**Case Officer:** Andrew Lewis

**Applicant:** Heyford Park Developments Ltd

**Proposal:** Discharge of conditions 5 (full details of accesses, driveways and turning areas) 6 (covered cycle parking facilities) & 11 (vision splays) of 19/00439/REM

TYPICAL MANHOLE DETAIL TYPE 2

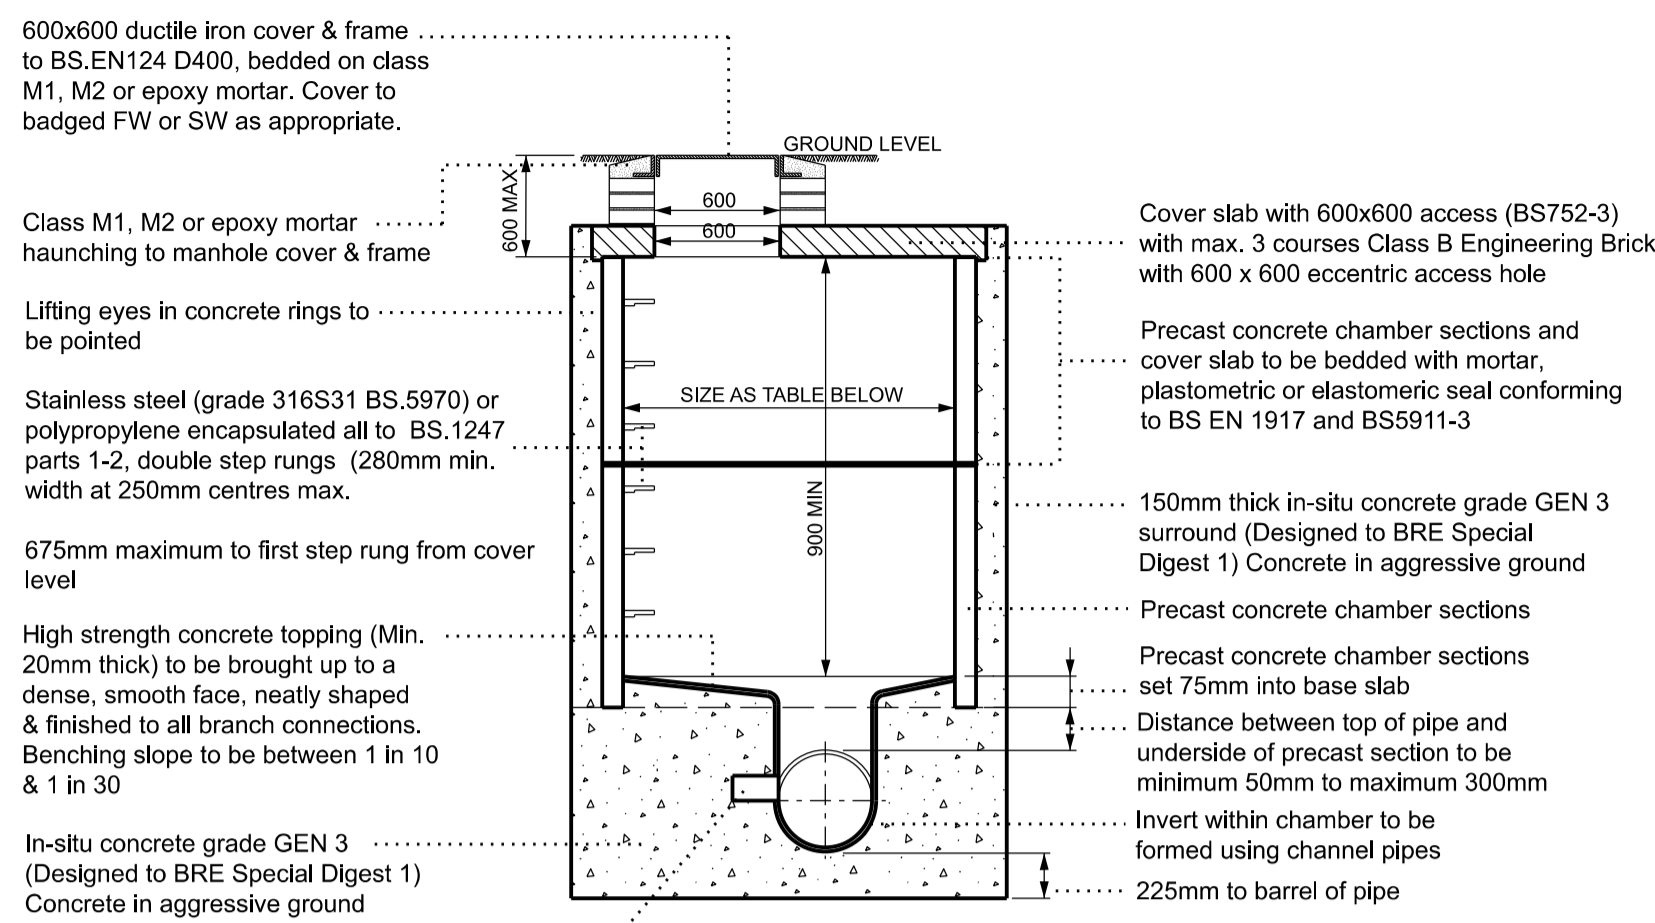
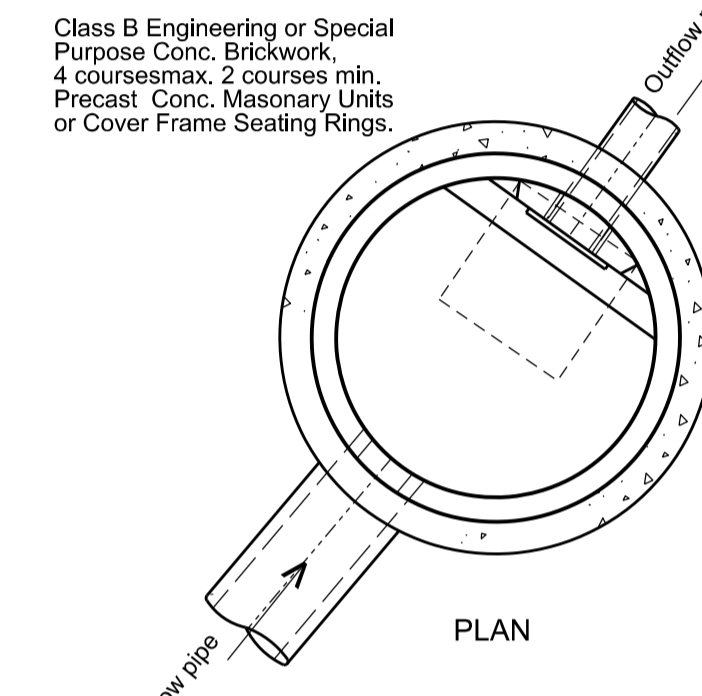
- Condition 5 Accesses, driveways and turning areas - No safety issues are presented. The following adoptability issues should be noted. • Over-run strip possibly not needed and wider footway could be provided instead. • The drawings specify manholes as opposed to catch pits, but this will be a Thames Water adopted sewer so this may not be an issue. • A couple of trees will require tree pits and commuted sums.
- Condition 6 Cycle parking - Each dwelling is provided with a shed of a suitable size for the storage of bicycles.
- Condition 11 Visibility splays - Visibility splays are adequate.
